CROSSROADS MIXED USE FILING NO. 1

CONSTRUCTION PLANS

EL PASO COUNTY FILE NO. SF 21-029

STREET IMPROVEMENT PLANS

Figure 13: Roundabout, Plan View

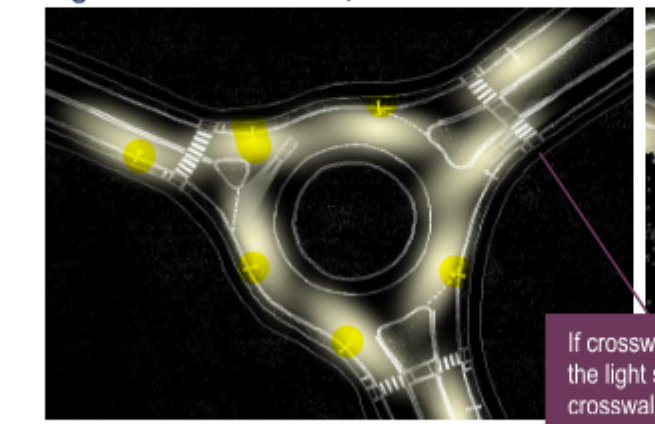
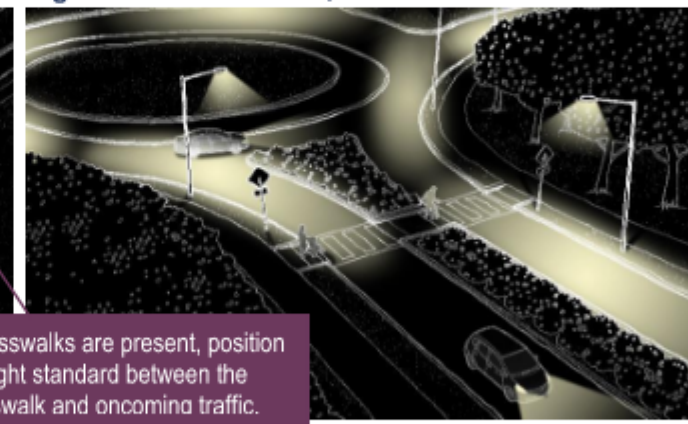
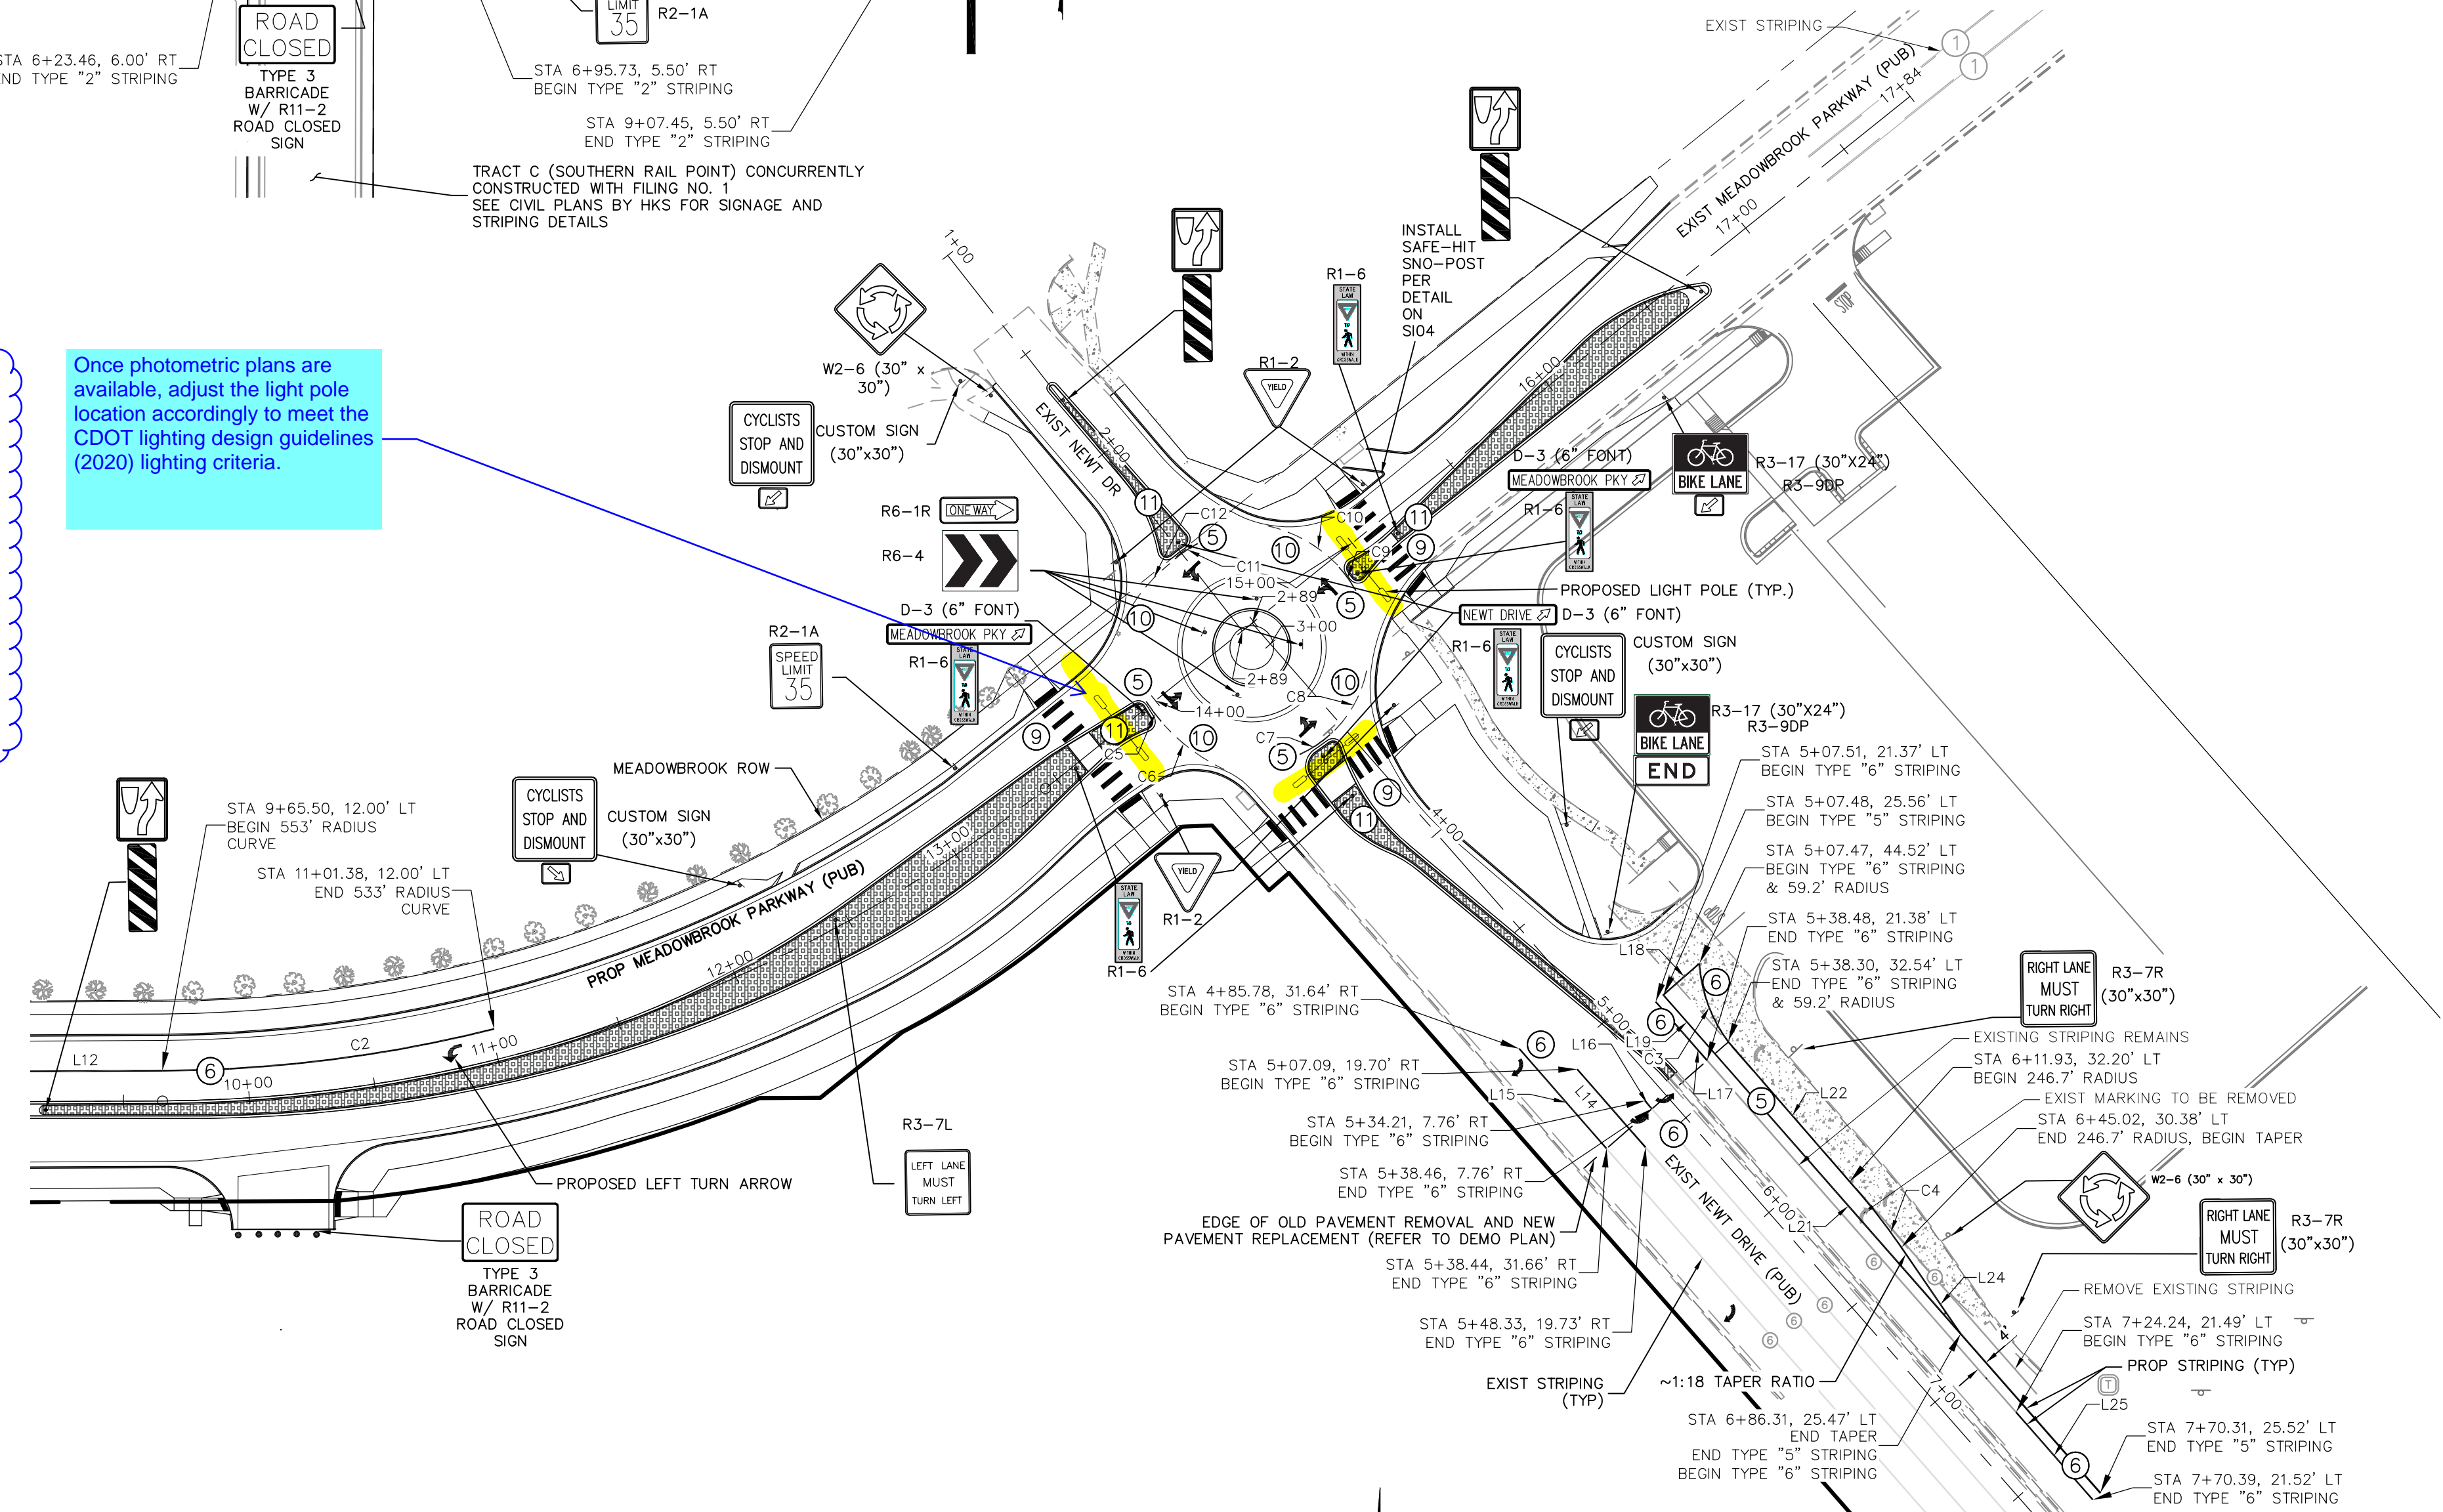
Coordinate with the traffic engineer. The roundabout configuration does not match the roundabout analysis. This will be reviewed on the resubmittal.

Pending. The second submittal did not include an updated roundabout analysis to address review #1 redline comments. Staff is unable to verify.

Unresolved. See review #3 comments to the roundabout analysis and coordinate with the traffic engineer. The WB-50 autoturn exhibits shows the design vehicle is tracking onto the curbs at multiple locations.
